Department's Ref: SSD 6092 Our Ref: SYD13/00948/02  
File Number: A6120690 Contact: Xi Lin

**PROPOSED MIXED USE DEVELOPMENT AT BLOCK 8, CENTRAL PARK,  
CHIPPENDALE**

RMS has reviewed the application and raises no objection to the proposed development. However, RMS provides the following advisory comments to the Department for its consideration in the determination of the application:

DWG NO
DA:103

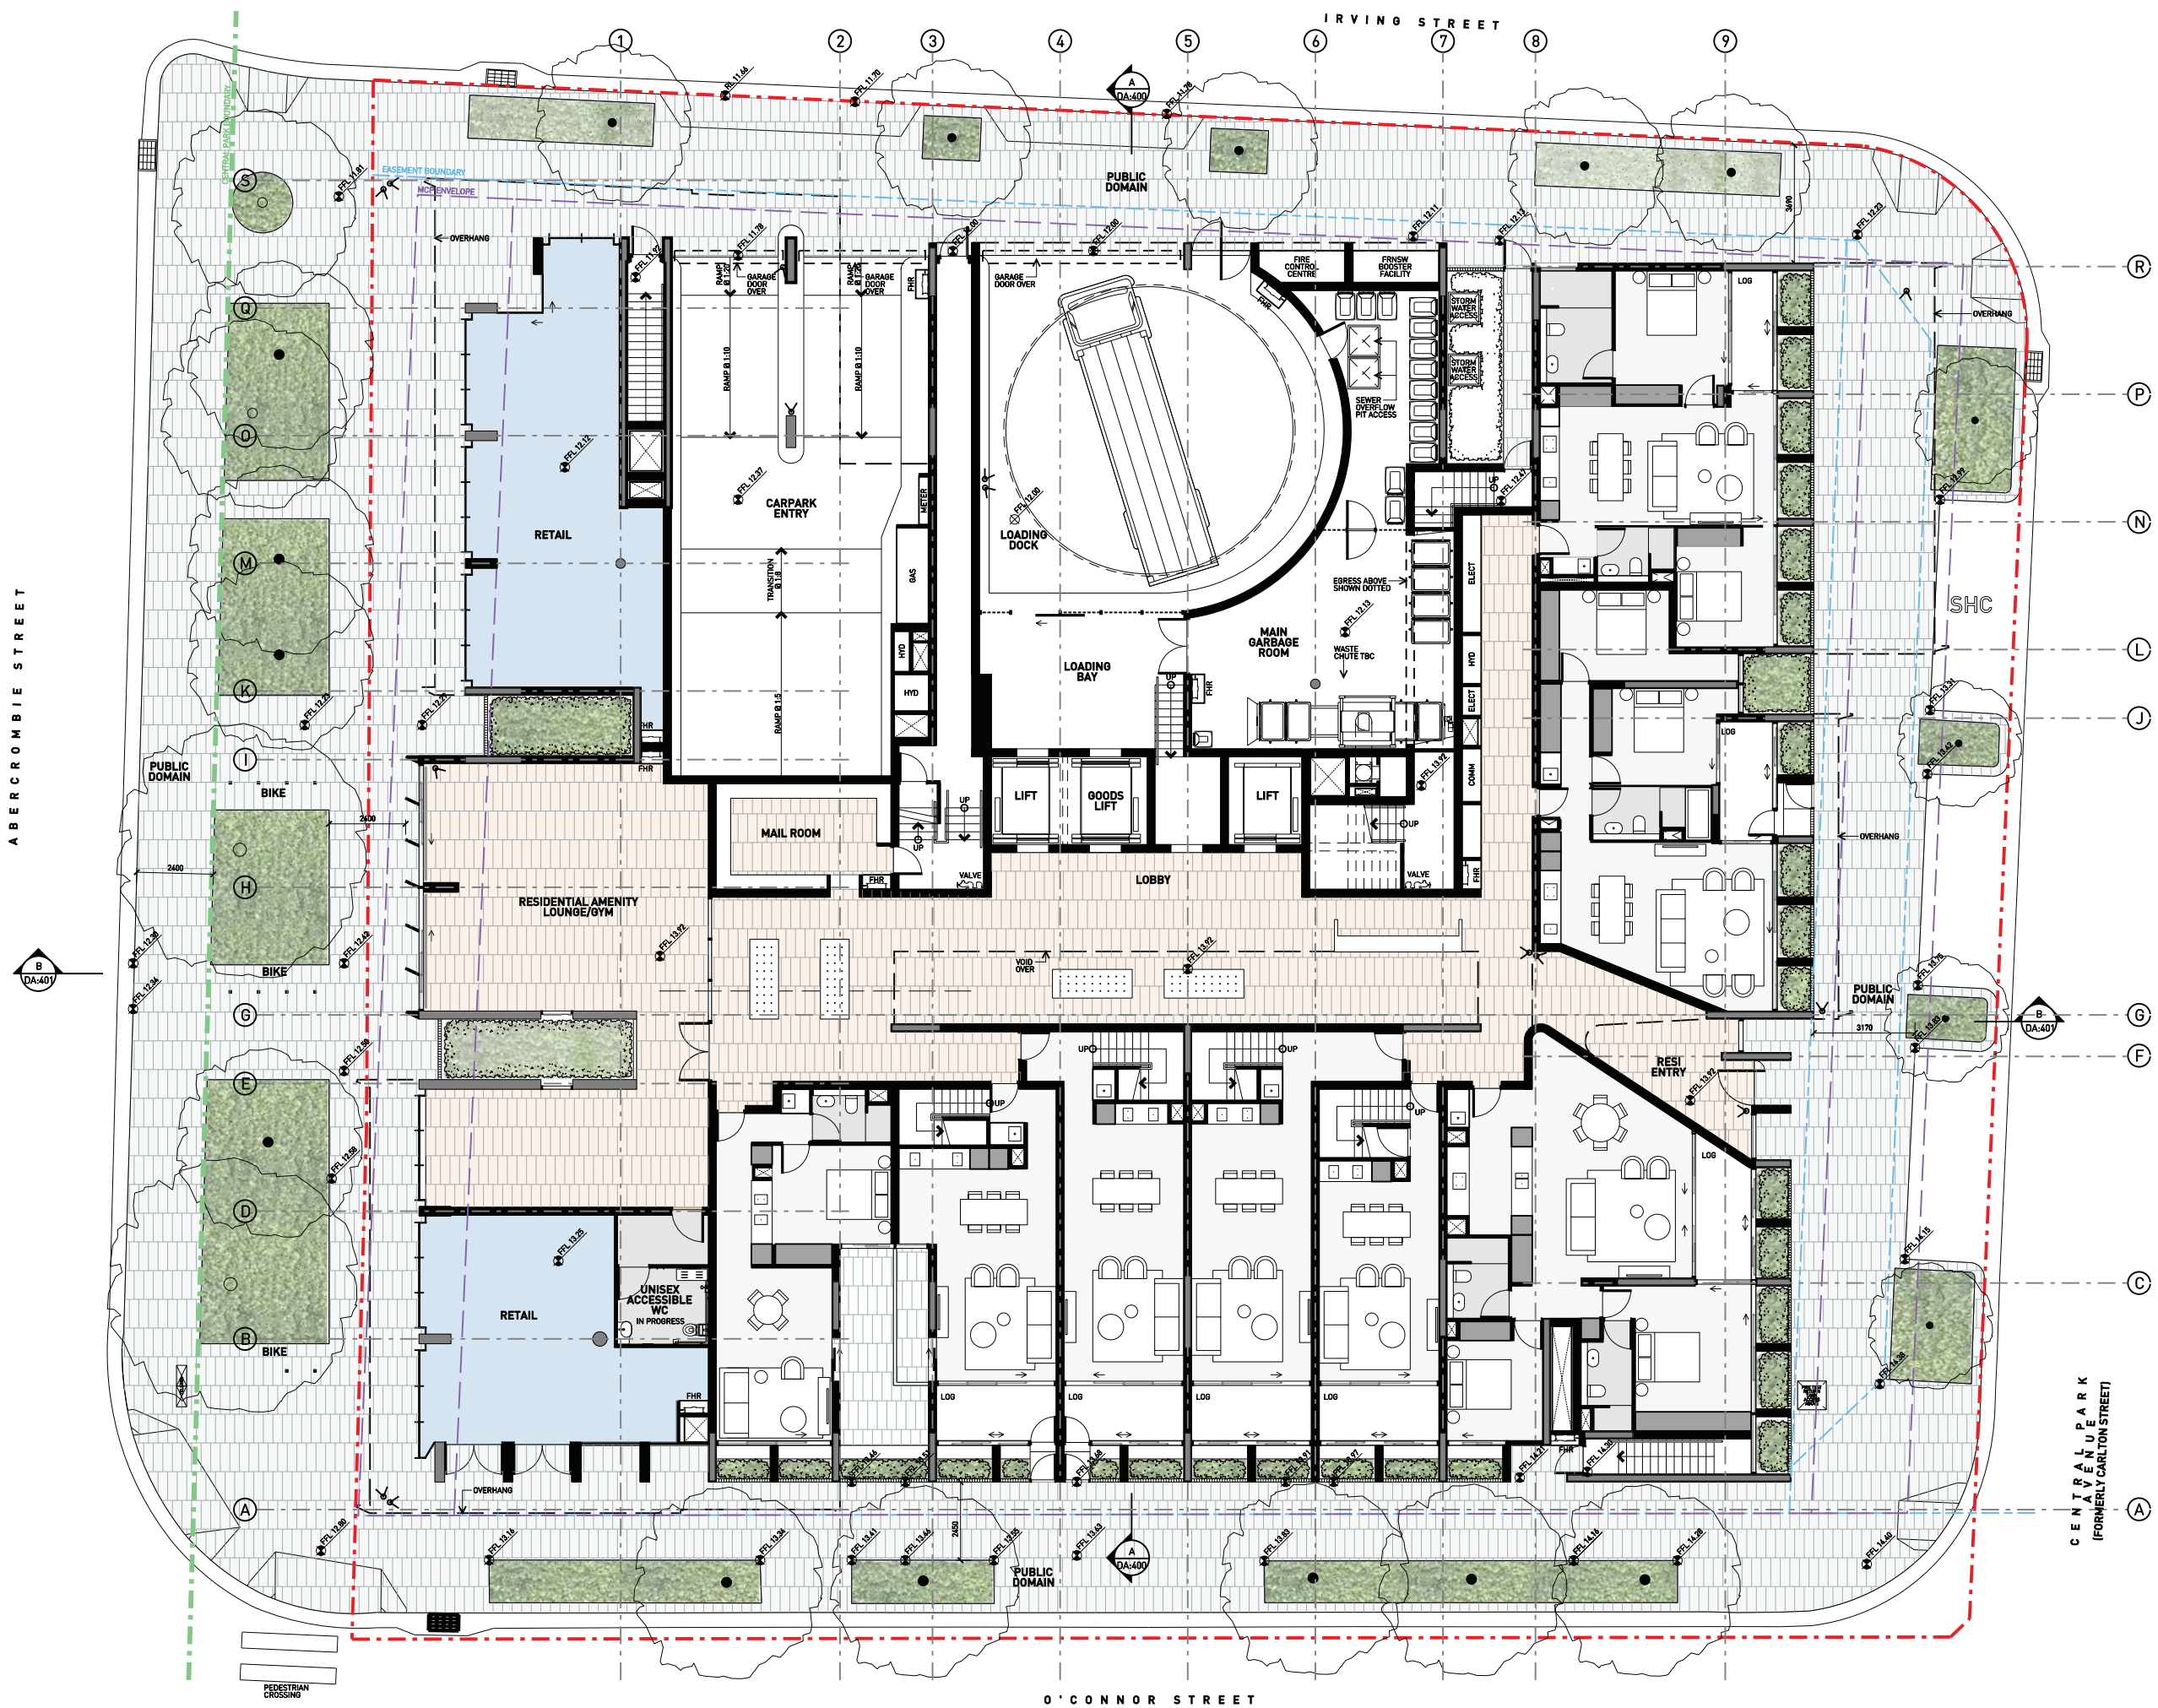
1. There are no objections to the development proposal on property grounds provided all buildings and structures are clear of the Abercrombie Street, road reserve (unlimited in height or depth).
2. The layout of the proposed car parking areas, loading docks and access driveway associated with the subject development (including, driveways, grades, turn paths, sight distance requirements, aisle widths, aisle lengths, and parking bay dimensions) should be in accordance with AS 2890.1- 2004 and AS 2890.2 – 2002 for heavy vehicle usage.
3. The developer is to comply with the requirements of the attached Technical Direction (GTD 2012/001). This will require the developer to submit detailed design drawings and geotechnical reports relating to the excavation of the site and support structures to the RMS for assessment. The developer is to meet the fill cost of the assessment by the RMS.

6. The swept path of the longest vehicle (including garbage truck) entering and exiting the subject site, as well as manoeuvrability through the site, shall be in accordance with AUSTRROADS. In this regard, a swept path plan shall be submitted to Council for approval, which illustrates that the proposed development complies with this requirement.

8. All demolition and construction vehicles are to be contained wholly within the site and vehicles must enter the site before stopping.
9. All works associated with the proposed development shall be at no cost to the RMS.
